KITTITAS COUNTY COMMUNITY DEVELOPMENT SERVICES

Subject: Palomino Fields Div 6 (LPF-21-00003) Final Long Plat – Staff Review, Request for Additional Information,

Kittitas County Community Development Services (CDS) received your Palomino Fields Division 6 (LPF-21-00003) Final Long Plat submittal on March 19, 2021. Kittitas County staff have completed review of your final plat submittal. As provided below, staff has the following comments, requirements, and/or revisions for your application that need to be addressed prior to final approval and signature of the final plat mylars:

PALOMINO FIELDS PLAT - DIVISION VI
 A REPLAT OF TRACTS 'E', AND 'H', PALOMINO FIELDS PLAT - DIVISION IV
 A PORTION OF THE S 1/2 OF THE NW 1/4 OF SECTION 27, TOWNSHIP 18 NORTH, RANGE 18 EAST, W.M.
 KITTITAS COUNTY, WASHINGTON

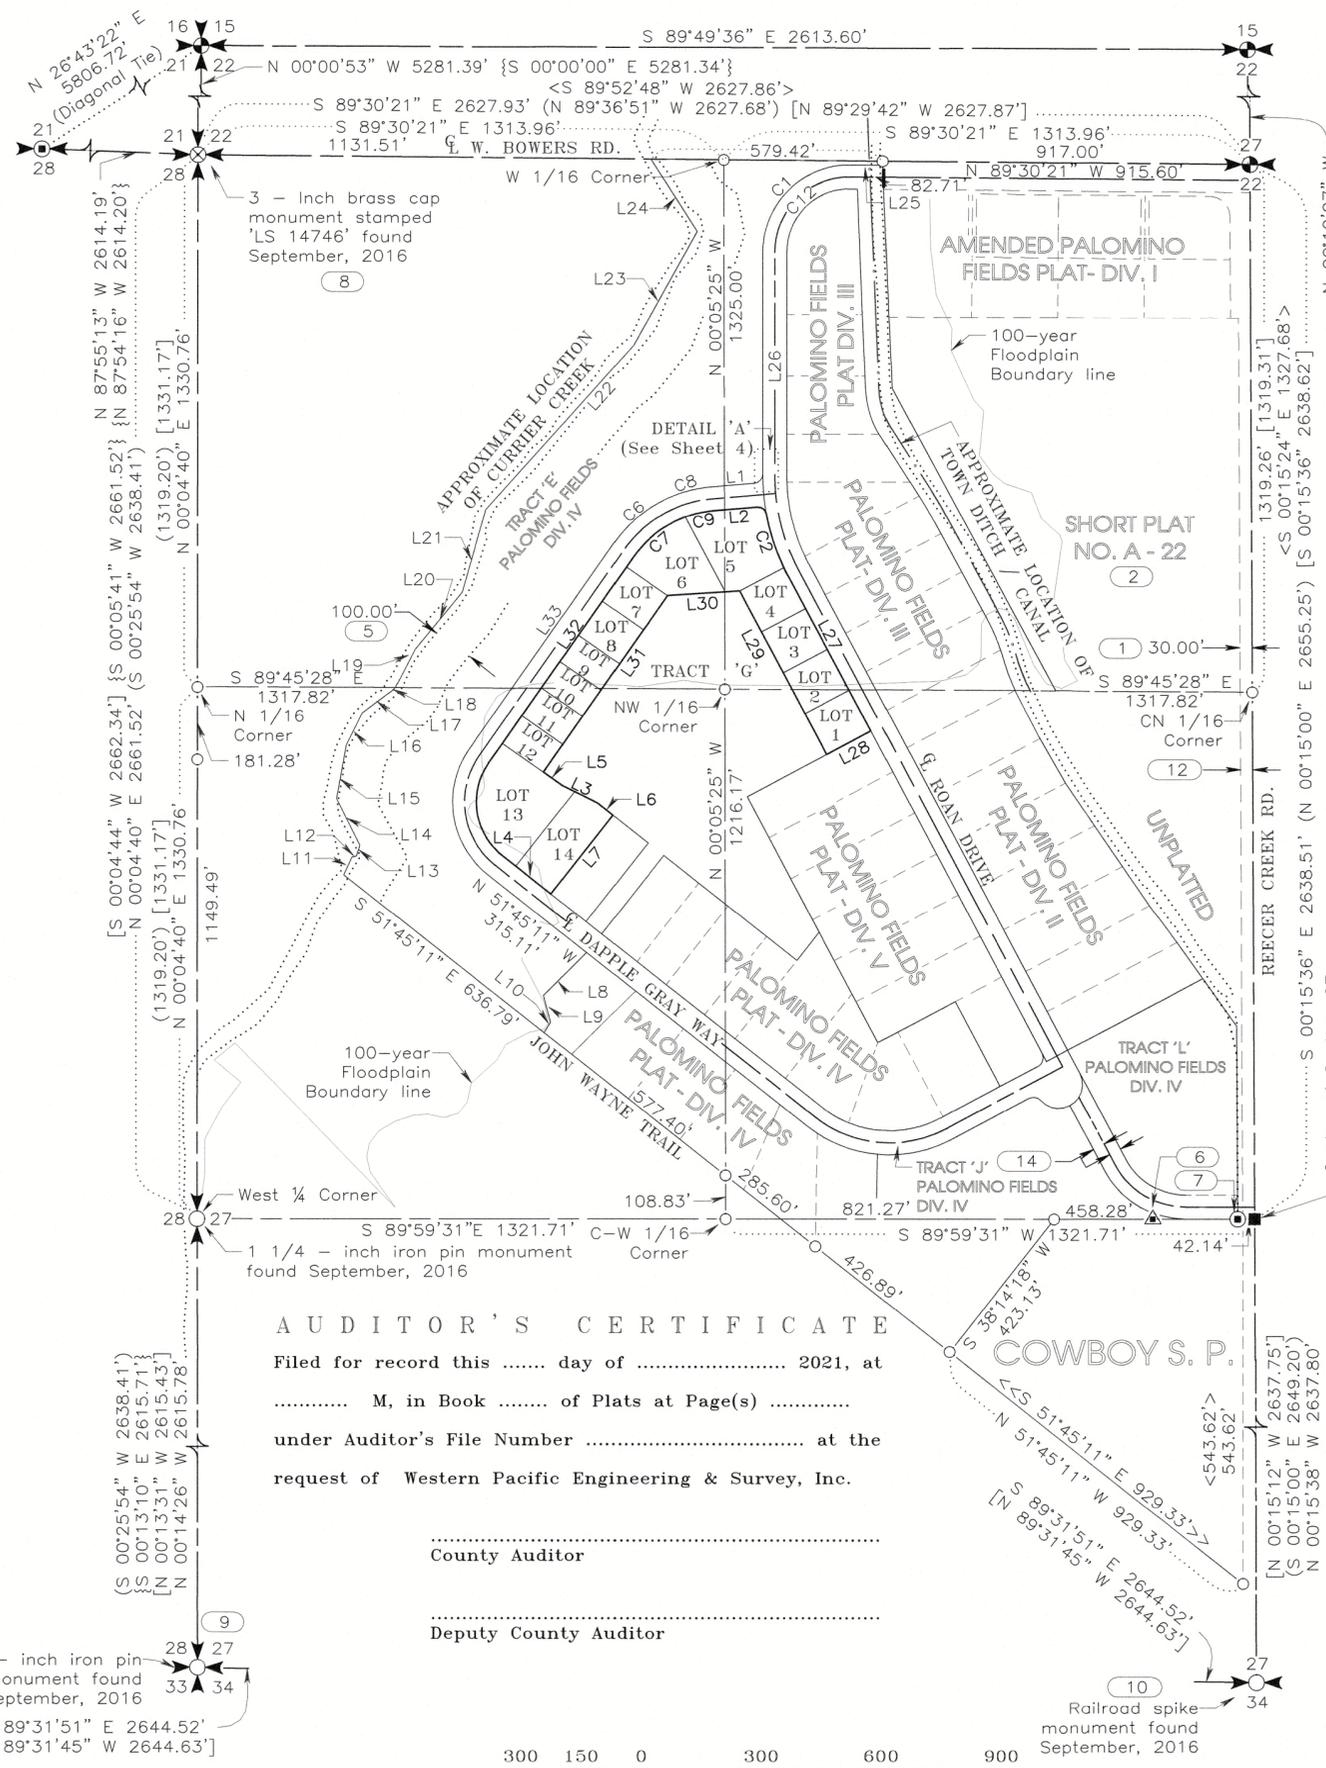
- The following file numbers shall be added to the face of the plat
LPF-21-00003
LP-07-00031
